Subject: Network Rail Consultation Response: BR/8/21/RES - Richmond Arms 224 London Road Bognor Regis PO21 1AU

Thank you for consulting Network Rail on the planning application BR/8/21/RES, please see our formal comments below.

Drawing Title:
PROPOSED SITE PLAN

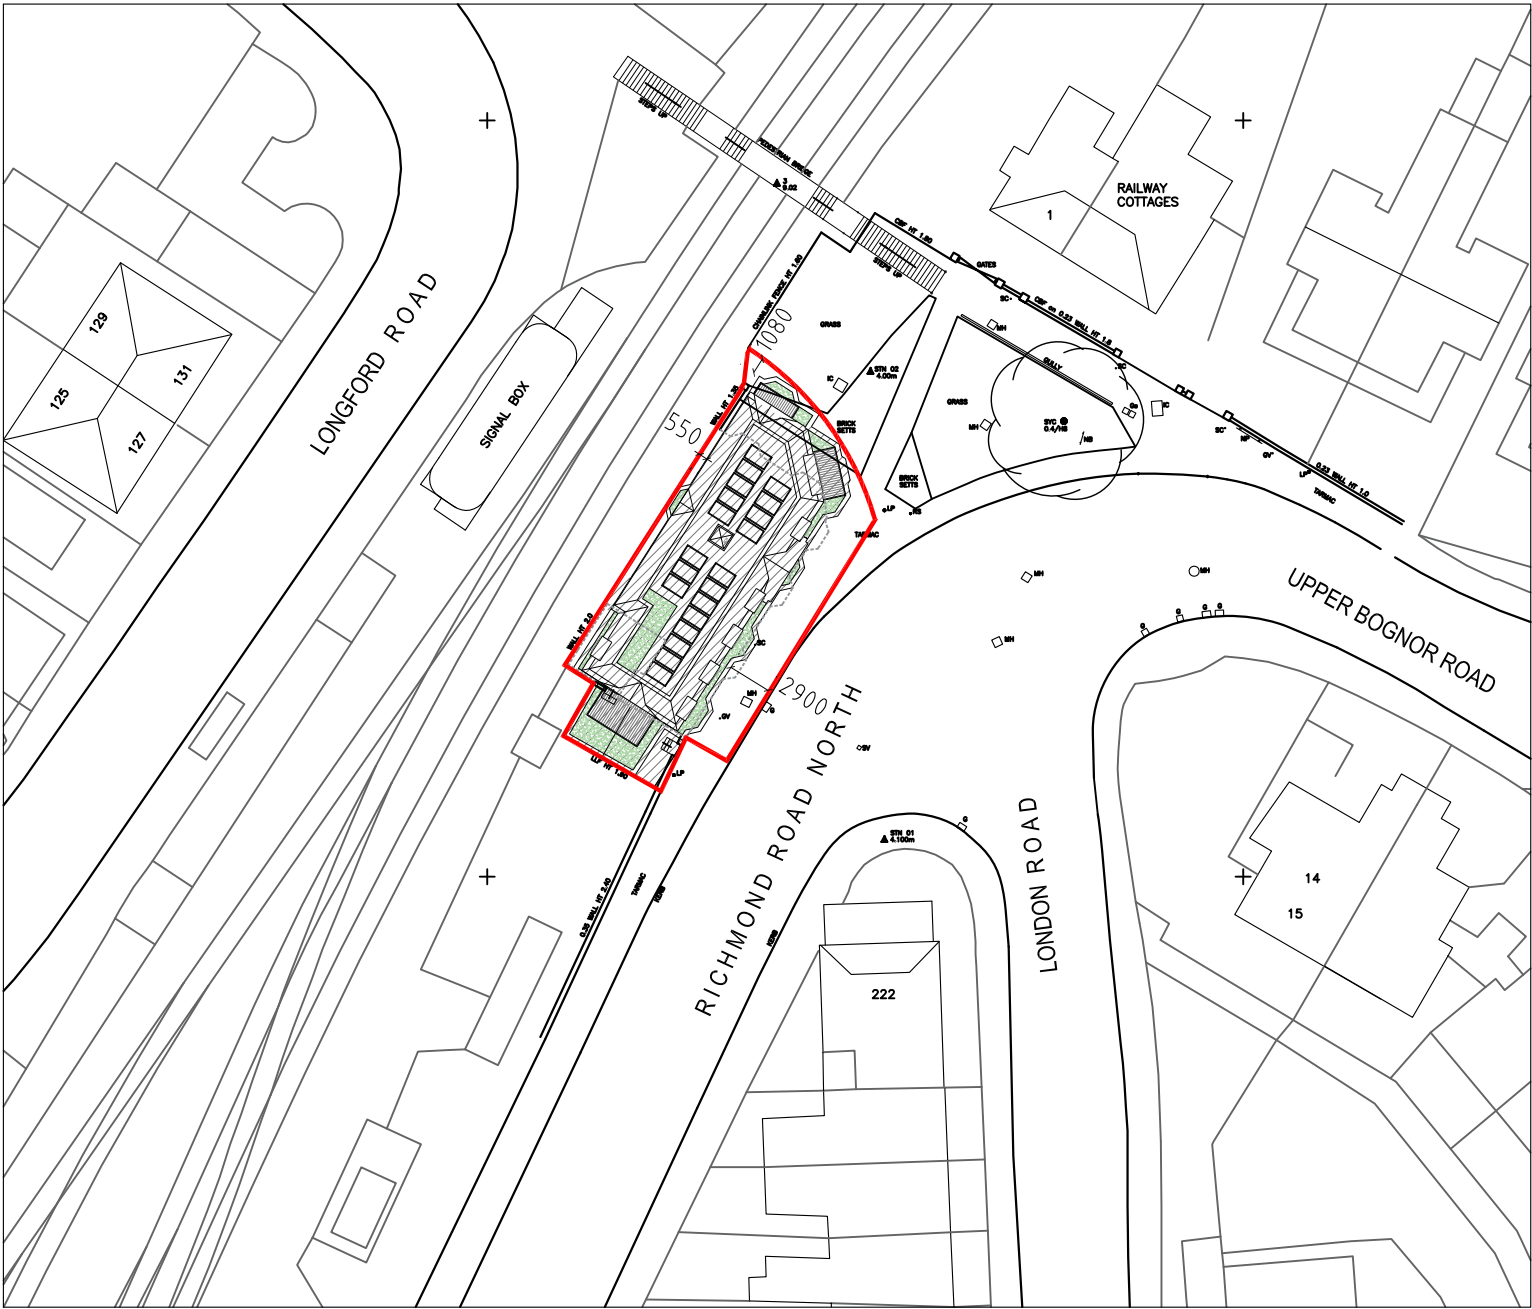
It appears that the proposed development is within 2m of Network Rail's boundary. Network Rail ask that all proposed buildings are situated at least 2 metres (3m for overhead lines and third rail) from Network Rail's boundary to allow for the construction and future maintenance of a building without the need to access the operational railway environment.

As a result, Network Rail requests the applicant / developer contacts Network Rail's Asset Protection and Optimisation (ASPRO) team via [redacted] prior to works commencing. Our Asset Protection team will review the details of the application to ensure that the proposed development can be completed without any risk to the operational railway. The applicant / developer may be required to enter into an Asset Protection Agreement to get the required resource and expertise on-board to enable approval of detailed works. More information can also be obtained from our website <https://www.networkrail.co.uk/running-the-railway/looking-after-the-railway/asset-protection-and-optimisation/>.
